From: Simon Davis
Sent: 19 July 2018 11:16
To: Karen Parsons
Subject: FW: AL/136/17 - Land West of, Fontwell Avenue, Eastergate, PO20 3RU

Please see final response from Highways raising no objection subject to conditions. They just require one final small change to the red edge as per the below paragraph:

2018-4370-001

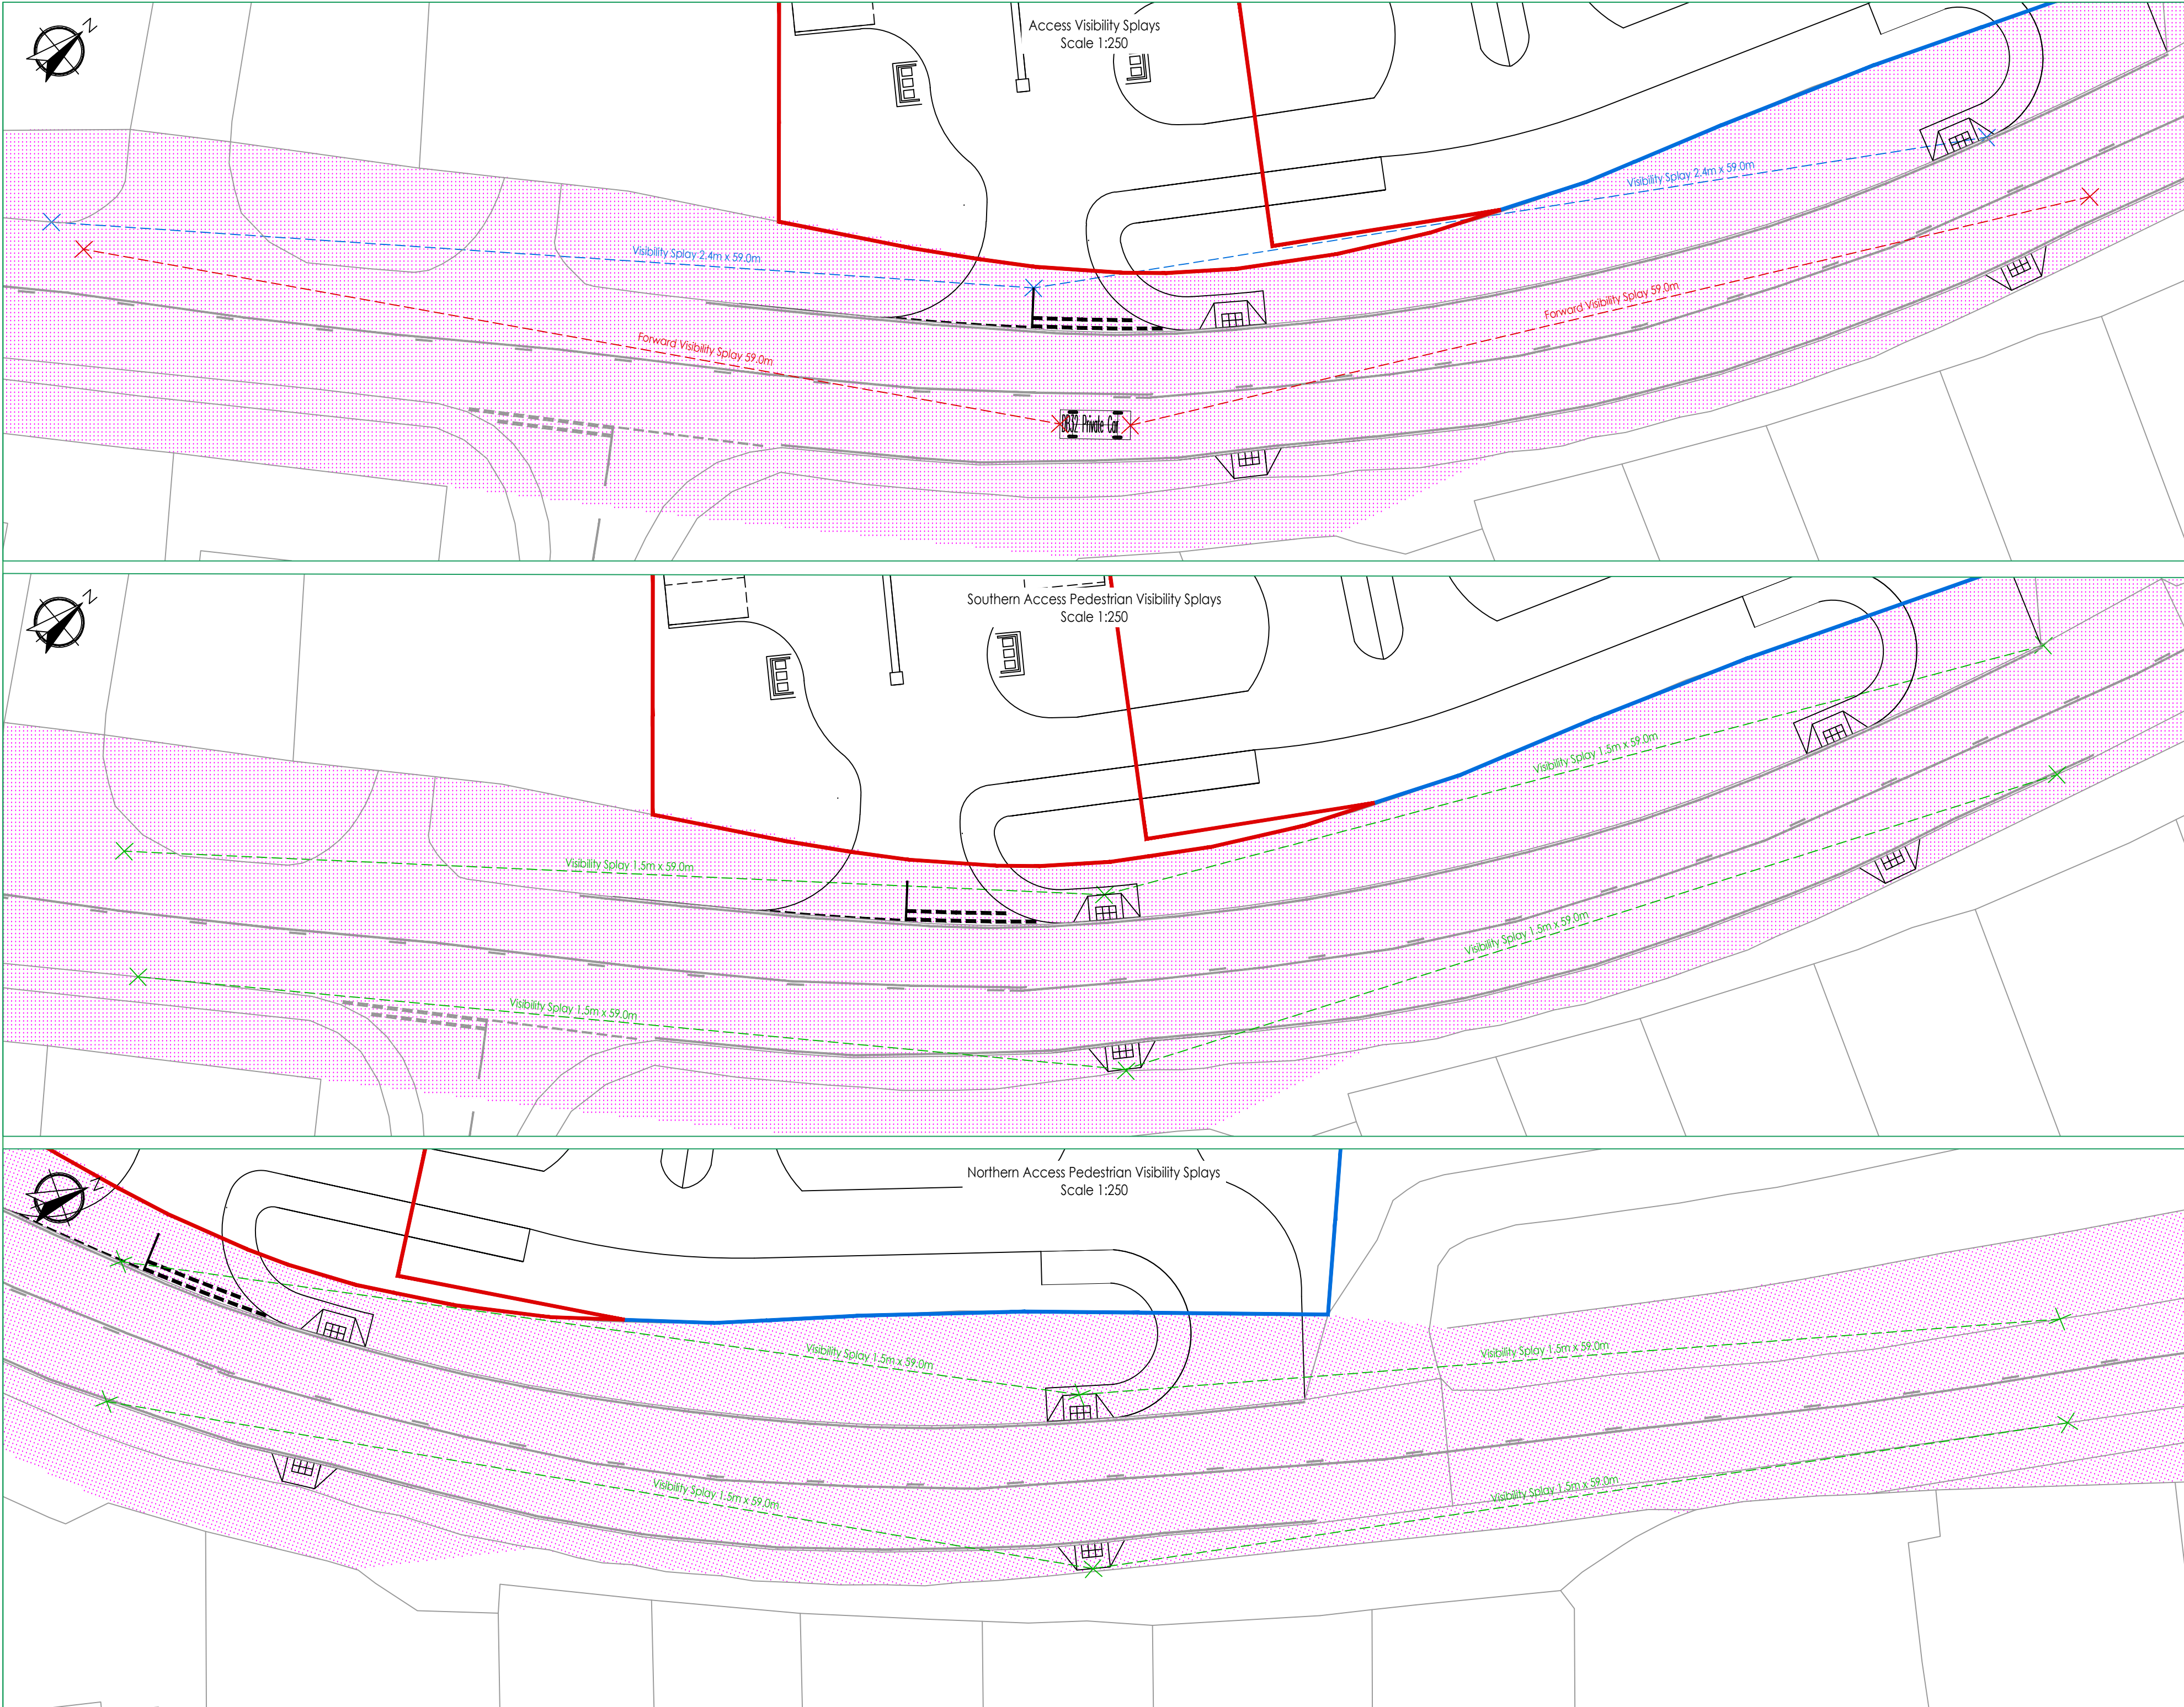
"Using the latest submitted plan it is however possible to plot a 2.4 x 59 metre splay, however there would be a requirement to use land outside the red edge to provide such a splay. This land is etched in blue on plan 2018-4370-001 and therefore it is not unreasonable that the applicant could secure this land to provide adequate visibility splays by way of planning condition. The Local Planning Authority is advised that this would require an amendment the red edge plans submitted."

Can you provide new plans to reflect this change. We do not consider it necessary to re-consult the Parish Council or Neighbours on this change. However, I will need an Extension of Time until the 7th September as this will not now be able to go to the August Committee. The next committee is the 5th September.
